A46 Newark Bypass

TR010065/7.38

7.38 Table of Errata

November 2024

Viewpoint 18: View north-west from Newark Castle representative of views for visitors to the castle and gardens.

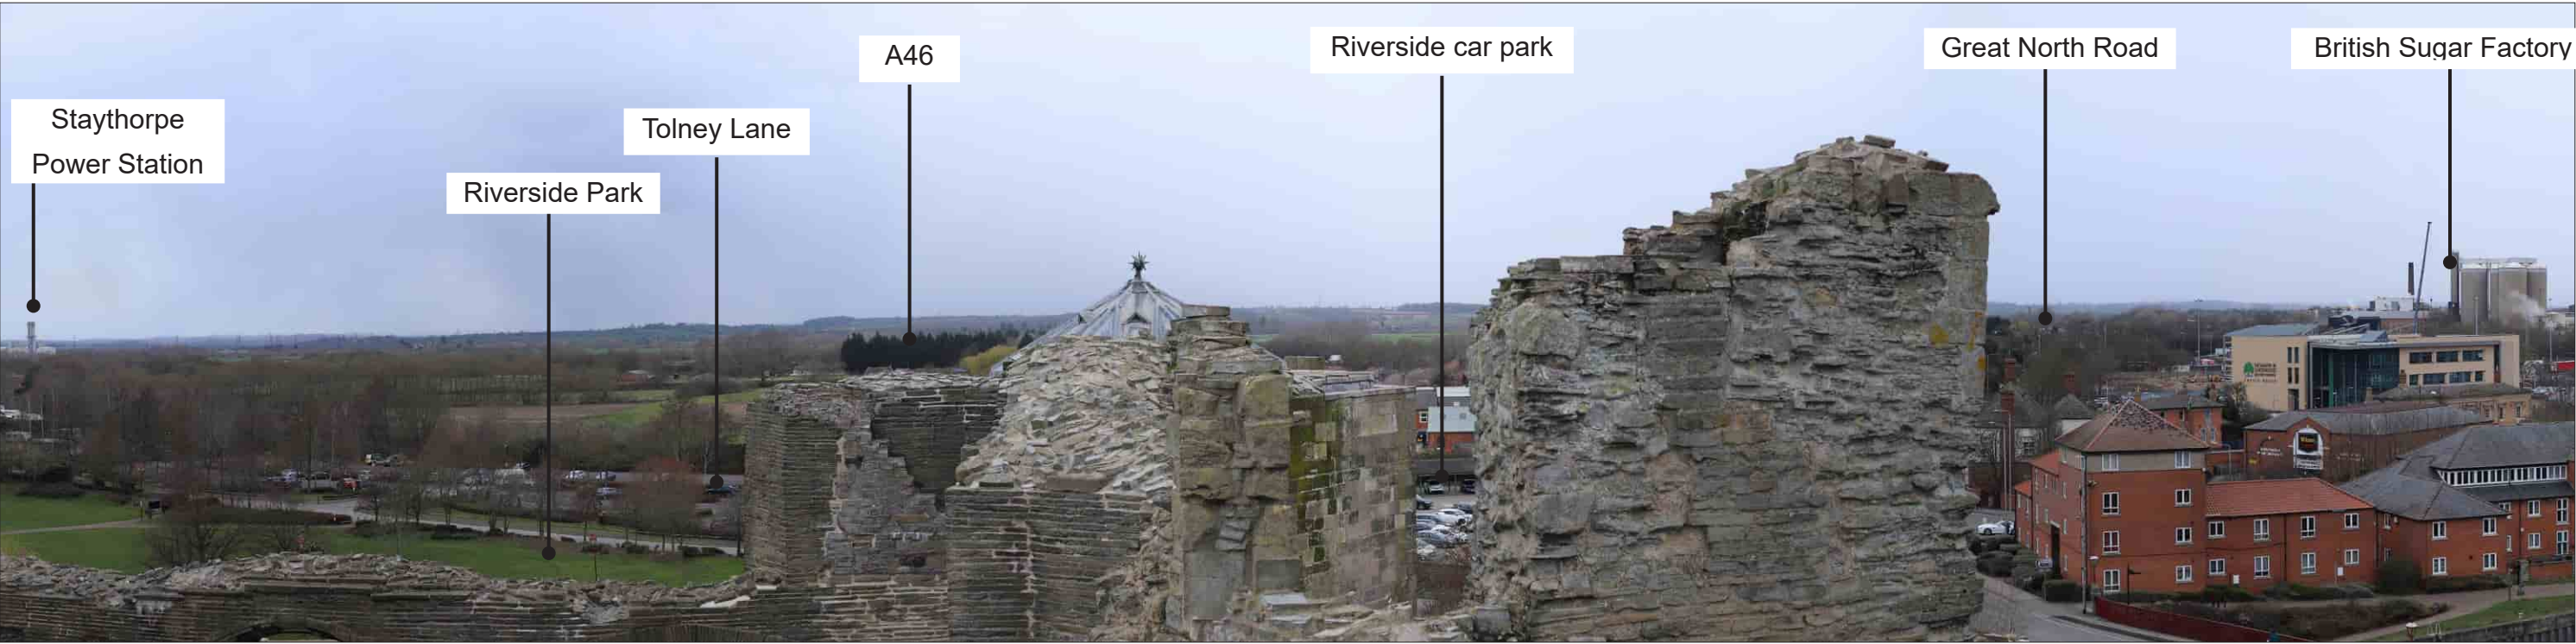
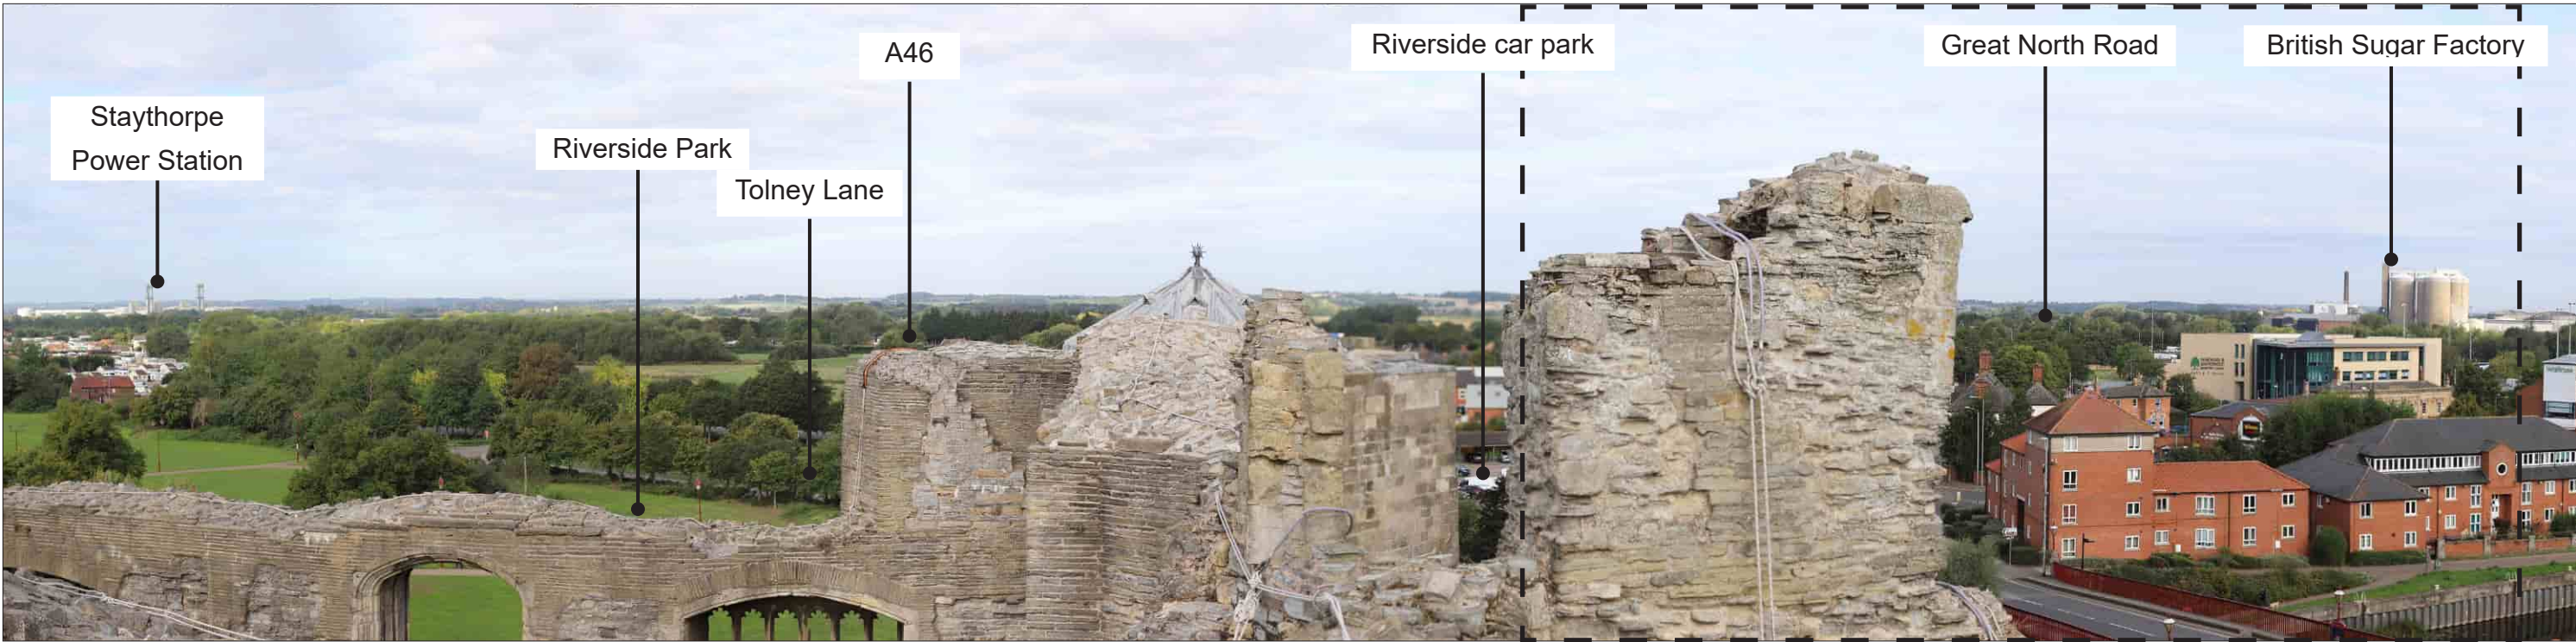
Response to Relevant Representations							
6.2.1	APP-138	Appendix 7.3 (Key Visual Receptor Photographs and Photomontages Part 1) of the Environmental Statement Appendices	16	Viewpoint 18: View north-west from Newark Castle representative of views for visitors to the castle and gardens	Identified by NSDC in RR-048	Spelling error	Applicant confirmed in response to relevant representations that the label on Viewpoint 18 should read " Staythorpe Power Station ", not " Stanhope Power Station ".
